Phone: 0300 123 6780
Email: developeras@lancashire.gov.uk
Your ref: 3/2025/0564
3/2025/0565
Our ref: 3/2025/0564/HDC/KW
3/2025/0565/HDC/KW
Date: 18 December 2025

Location: 45 - 47 Whalley Road, Clitheroe, BB7 1EE
Proposal: Planning permission for proposed change of use from light industrial to residential (use class C3) and commercial (use class E(c)(iii)) involving internal and external alterations.
Grid Ref: 374236 441280

Summary

No objection subject to conditions

drawing number
PL02

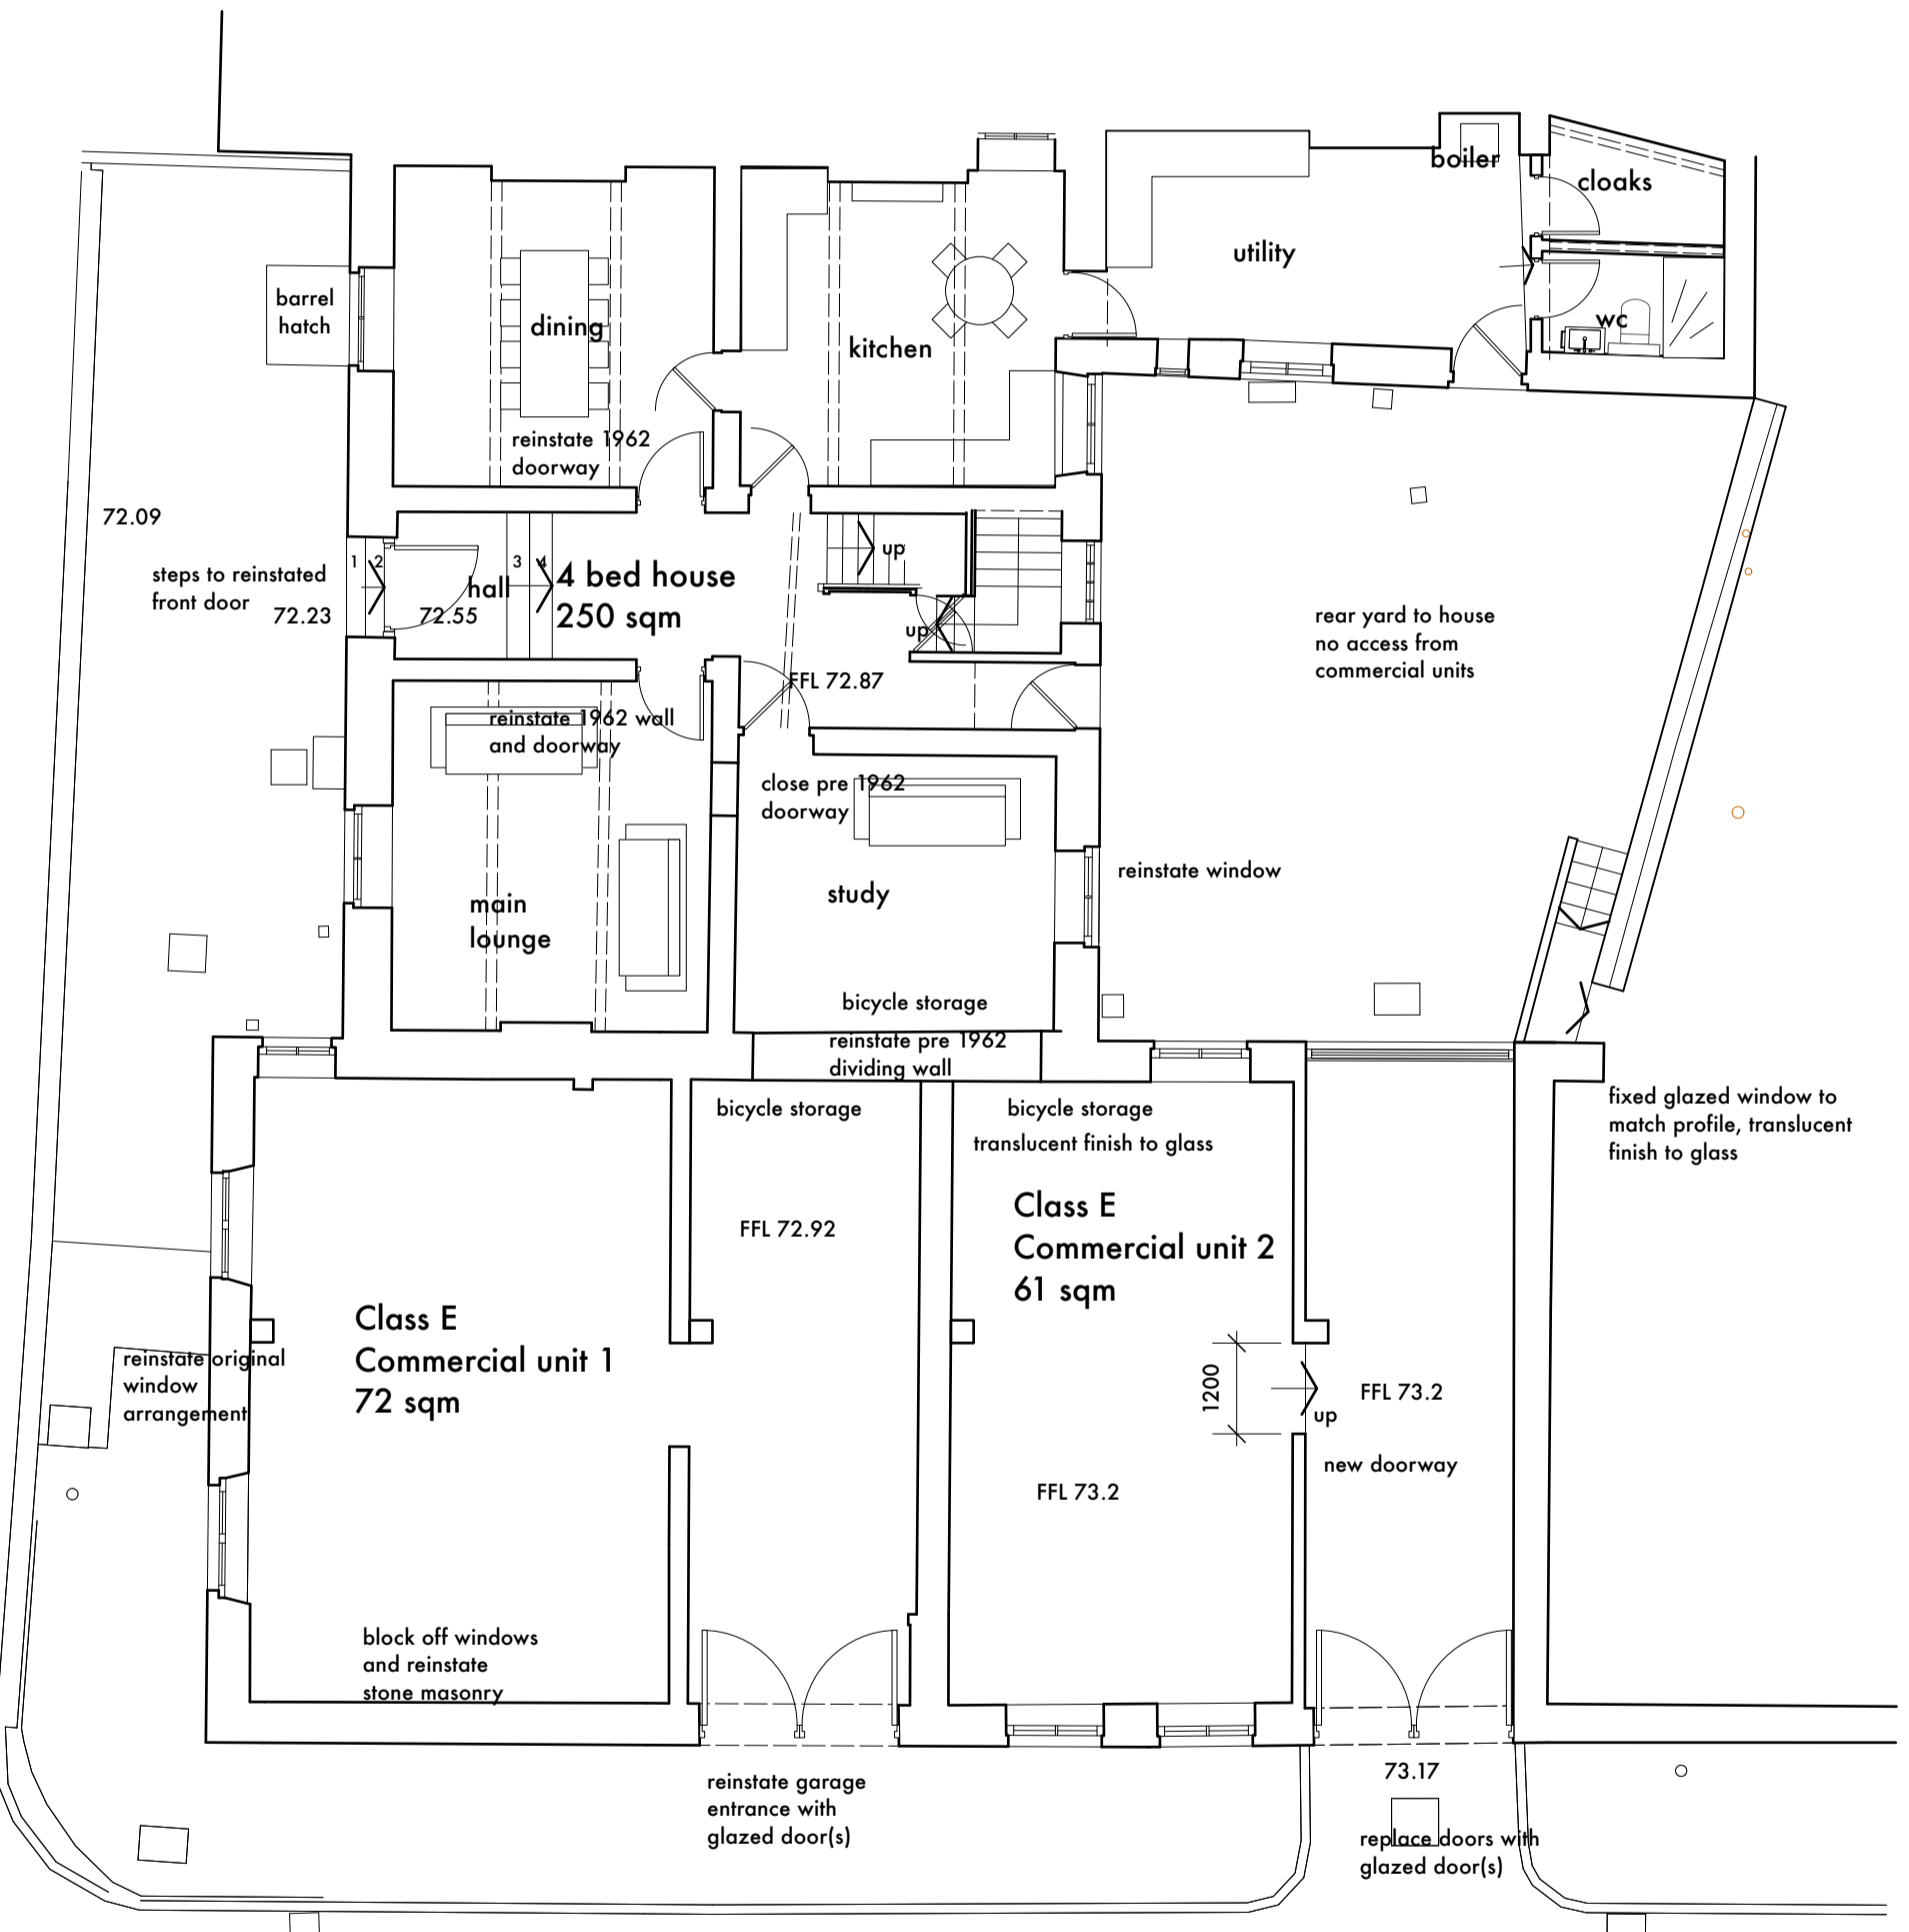
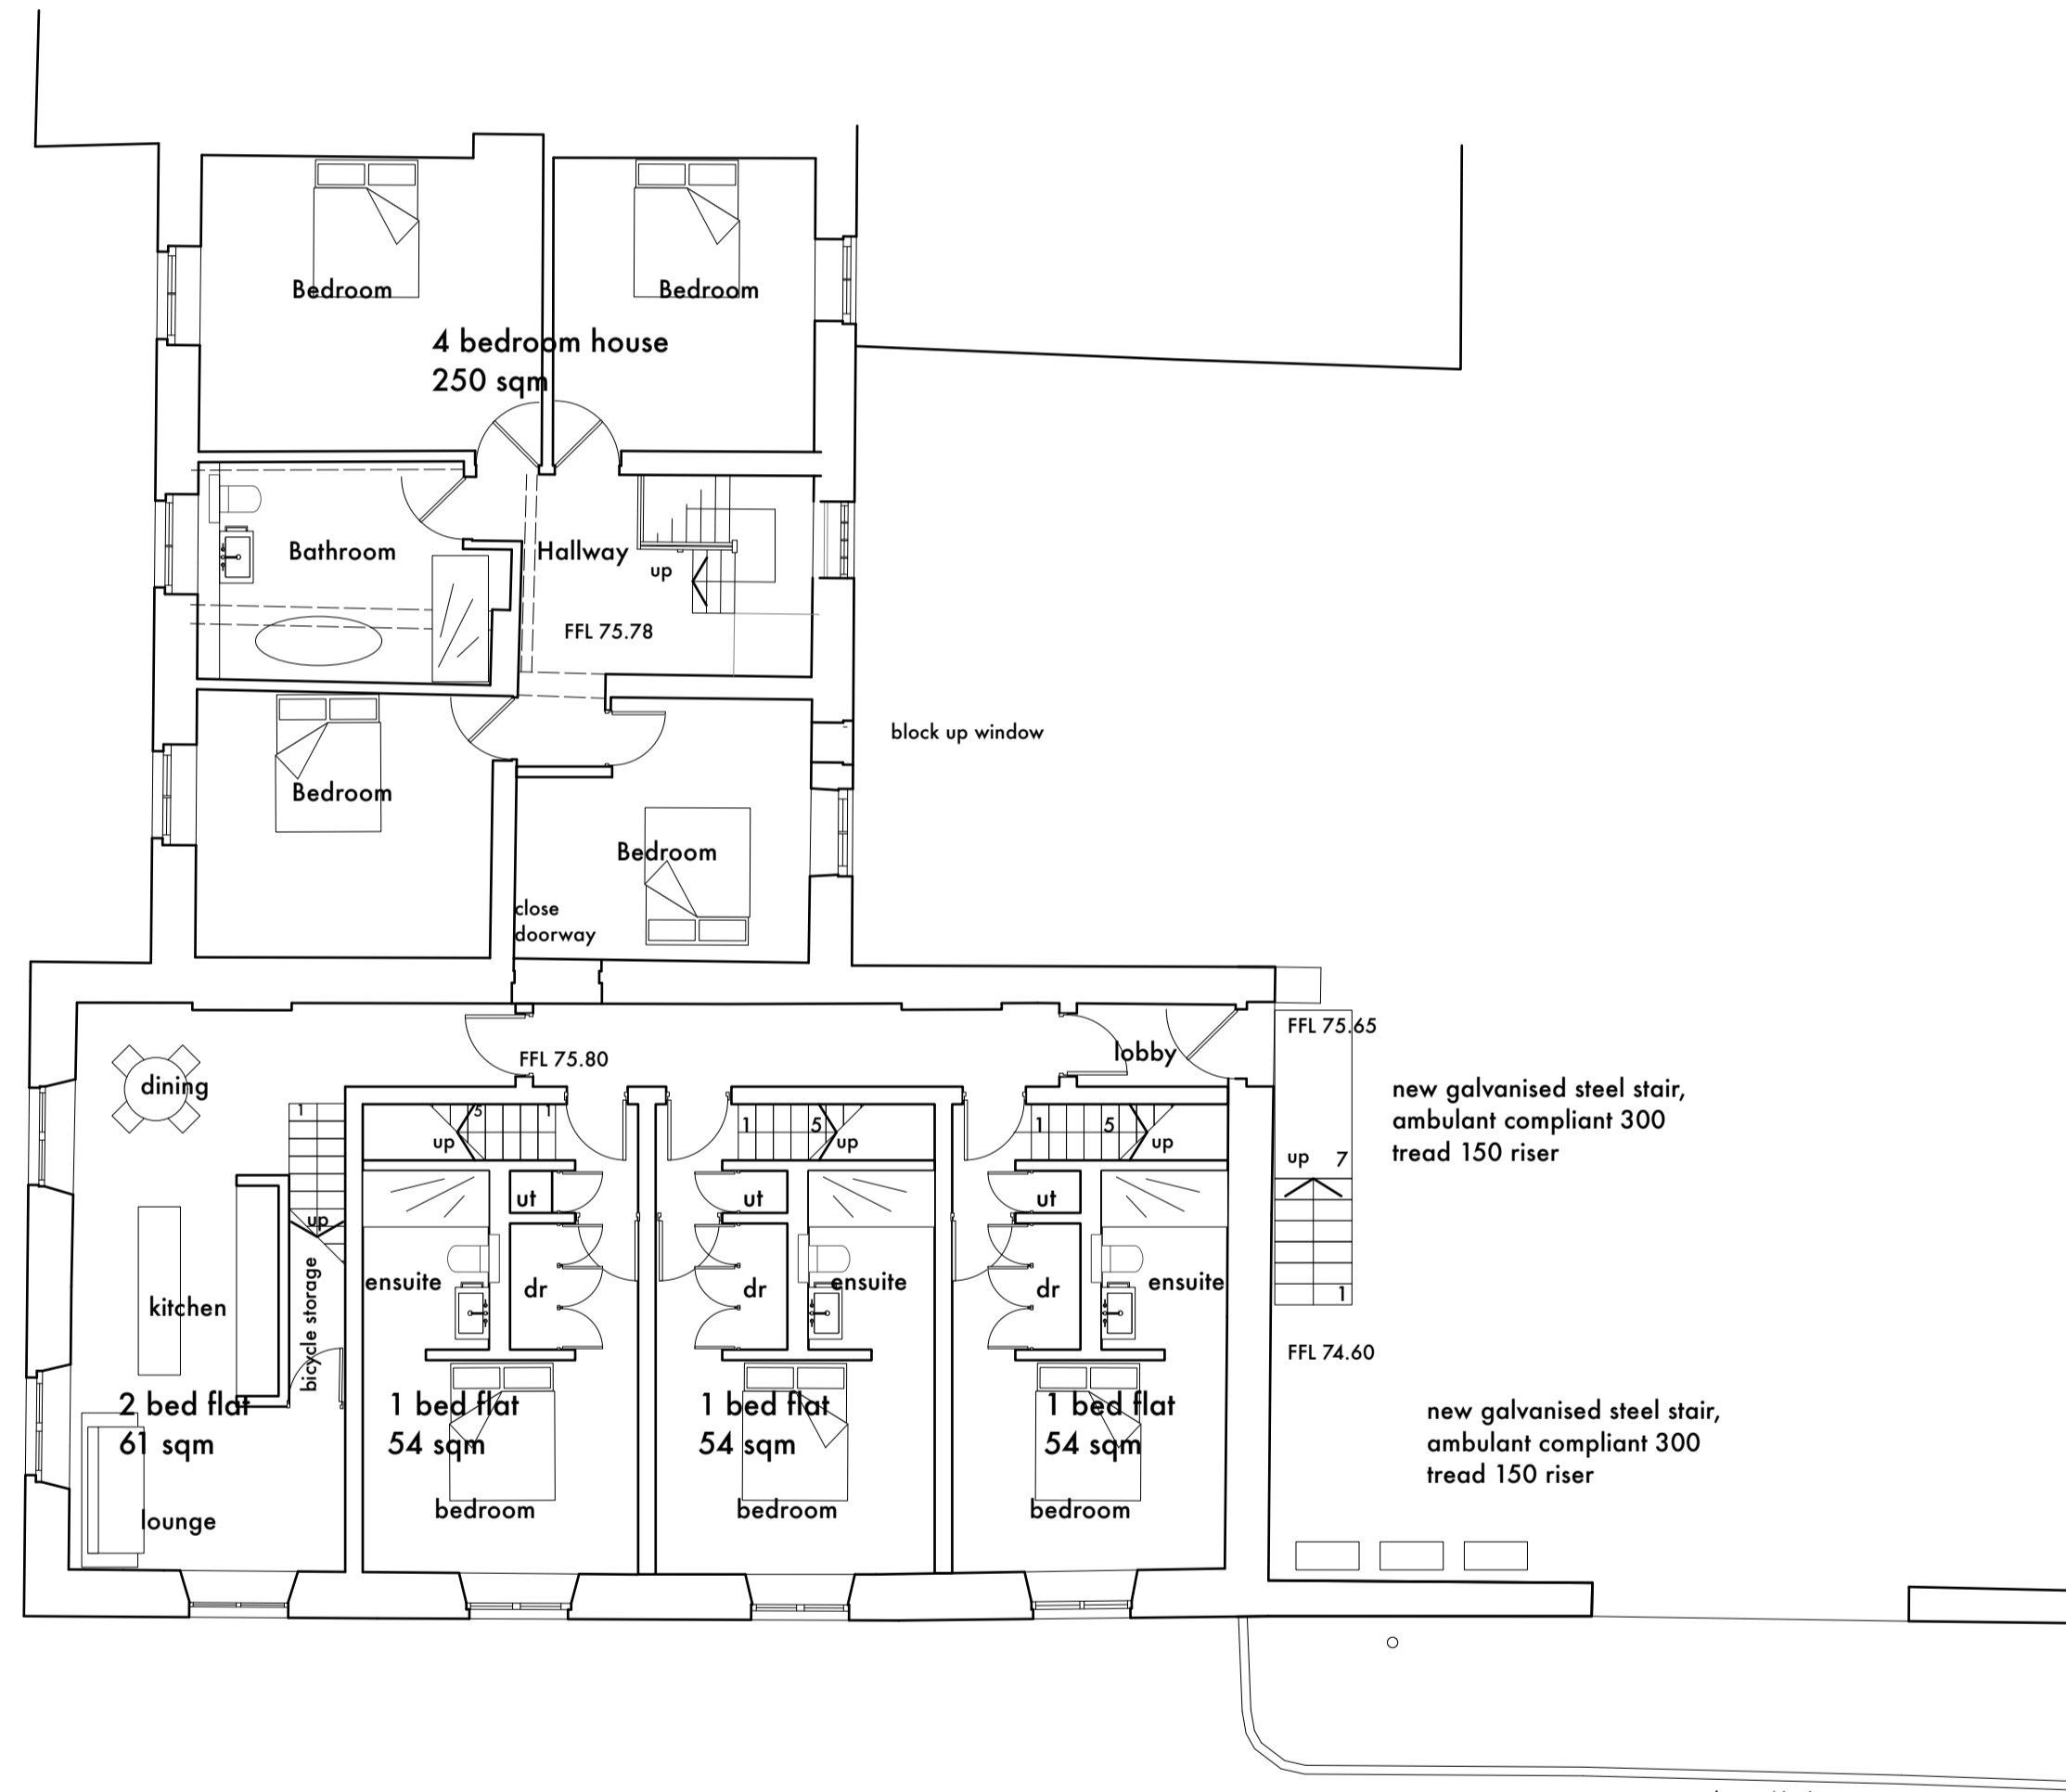
Four parking spaces are allocated for the flats. Drawing number PL02 indicates that three one-bedroom flats and one two-bedroom flat are proposed. In accordance with the LHA's parking standards (as set out in the Joint Lancashire Structure Plan), one-bedroom flats should be provided with one off-street parking space each, and two-bedroom flats should be provided with two.

Although the LHA and Ribble Valley Borough Council have not yet updated their parking standards following the introduction of Class E use, the LHA applies an average of one car parking space per 35 square metres for Class E uses. Based on the internal floor layout, Unit 1 would require two parking spaces, and Unit 2 would require one.
